City of Sydney

9 December 2010

File No : S09/01810

Environmental Assessment for Sydney CityGrid Stage 2D

Figure 3: Riley Street Construction Compound Indicative Layout.

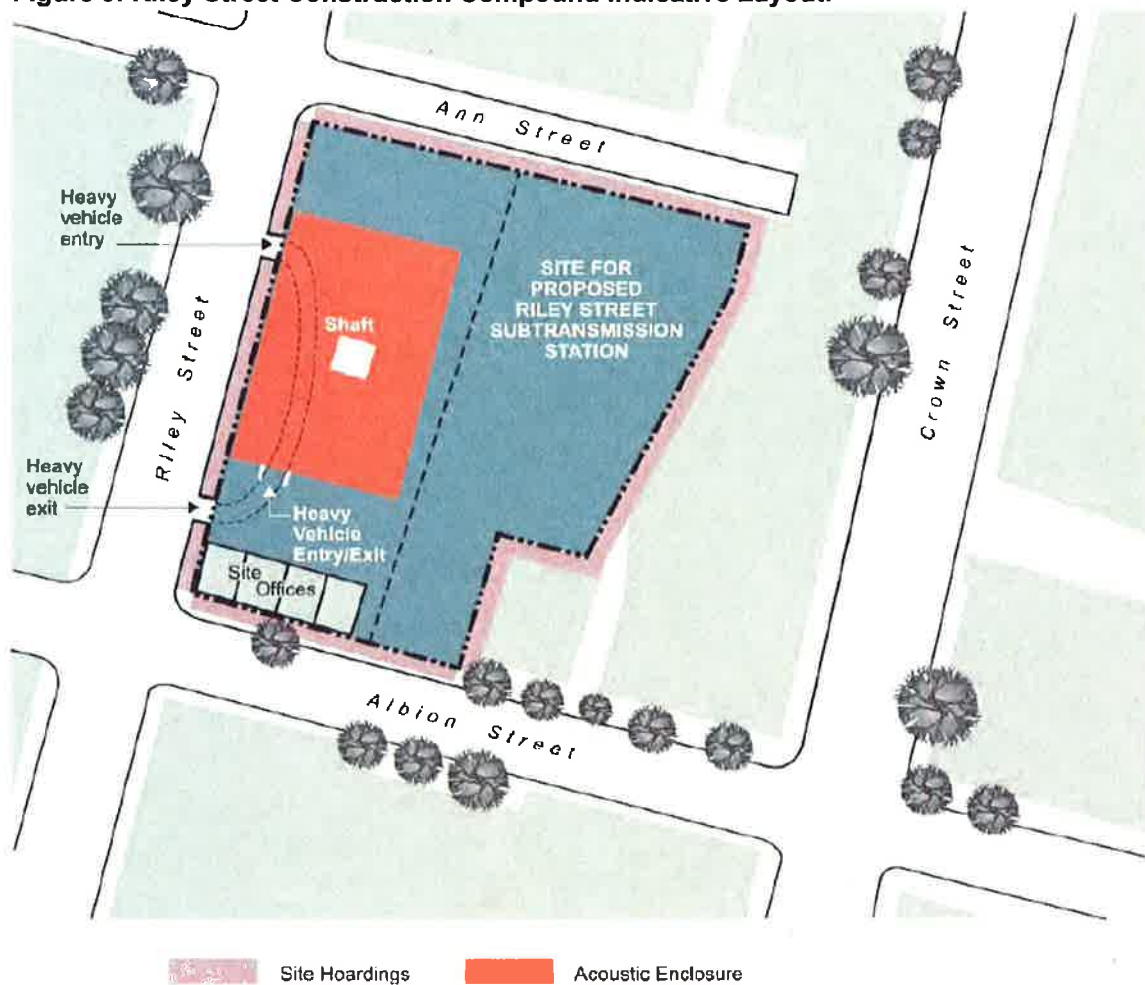
The proposed construction compound at the Surry Hills site, bordered by Ann, Riley, and Albion Streets has the potential to affect/require removal of trees surrounding the site.

This site is bounded by four (4) mature street trees located along the Riley St frontage, and three (3) other mature street trees are located along the Ann St frontage. These trees are not indicated on the indicative plan within the Energy Australia Environmental Assessment dated November 2010, as shown below, and there is no clear intention in the document whether the applicant intends to remove or retain these trees. Council has provided an aerial view of the site, below for reference, with the trees highlighted.

The street tree numbered 4 and circled in black above is in poor condition and may be removed if it is in conflict with the proposed vehicle entry point. Other trees circled in green are of medium-high retention value and must be retained.

- A number of trees have established within the Riley St site since it has been vacant. These trees are a range of species that have self seeded and should not be considered a constraint to the development.
- Any proposed tree removal is clearly detailed within appropriate plans and documentation, and that the City of Sydney is advised of any proposed tree removal at the earliest opportunity.
- The applicant is required to notify the community at the earliest opportunity of any proposal to remove street trees.
